Re: SSD6917 – Oakdale South Industrial Estate, TransGrid Easement Flood Extents

TransGrid has reviewed the stormwater drainage design for the Oakdale South Development and we make the following comments, taking into account the proposed construction of the raised hardstand pads for the warehouses on the edge of our high voltage transmission line easement.

SSD6917 - Oakdale South Industrial Estate, TL: Syd Sth - Syd West No.1 330kV (Fdr 30 Str 10-13 & Fdr 14 Str 110-111)	
Property of Transgrid. No warranty is given that information shown is complete or accurate.		PRODUCED FROM TAMIS	Scale: 1:15000
18/11/2015 15:14:49 Created by: P86665		A4

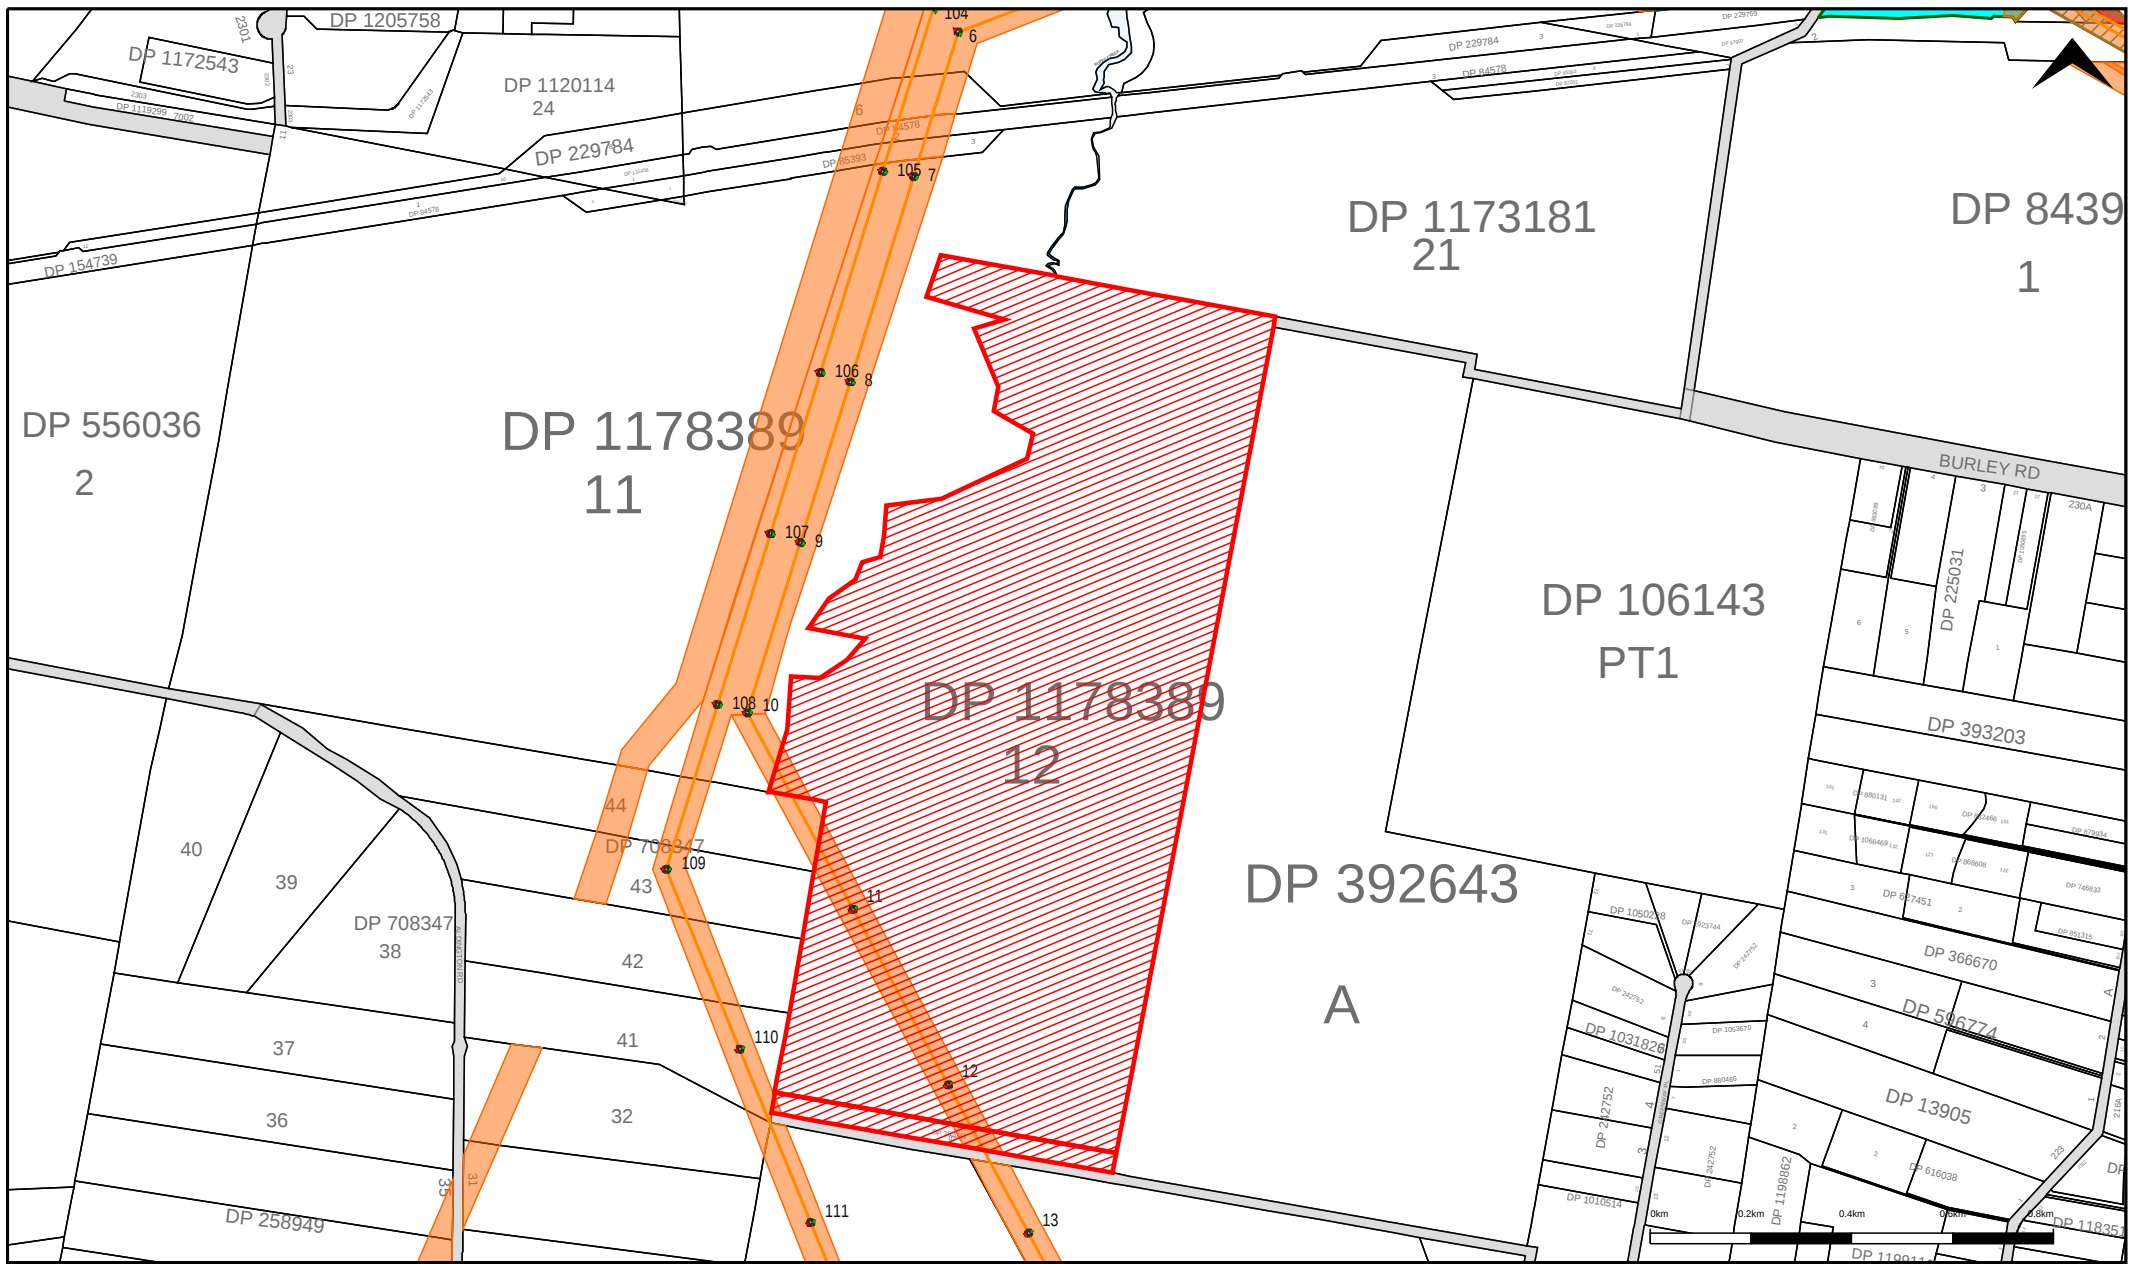
- TransGrid seeks to have the development include an appropriate drainage design to be constructed on the 1 metre inside edge of TransGrid's easement boundaries (on each side of the easement). This drainage needs to prevent water accumulating on account of the channelling effect that will arise from having the warehouse sites constructed on the immediate edge of TransGrid's easement, in particular the retaining walls supporting hard stand areas. Given the channelling effect of the adjacent developments, rainfall on the easement particularly in flood events needs to be directed to these rubble drains or swales on the easement boundary, emphasising the need to drain away from transmission towers.

- The design of the swale and any other ground works proposed on the easement, including batters, must not enable water to pool on the easement or form permanently sodden ground. Sodden ground adversely affects soil resistivity around earthing straps and TransGrid's ability to utilise the easement for maintenance of our high voltage infrastructure.

- A 25 metre horizontal clearance from each transmission tower leg must be preserved at all times, especially during construction. Transmission towers have subterranean earthing straps that protrude 15 metres diagonally out from each leg of a stanchion. Earthing straps are very hazardous if disturbed whilst the transmission line is under fault conditions.
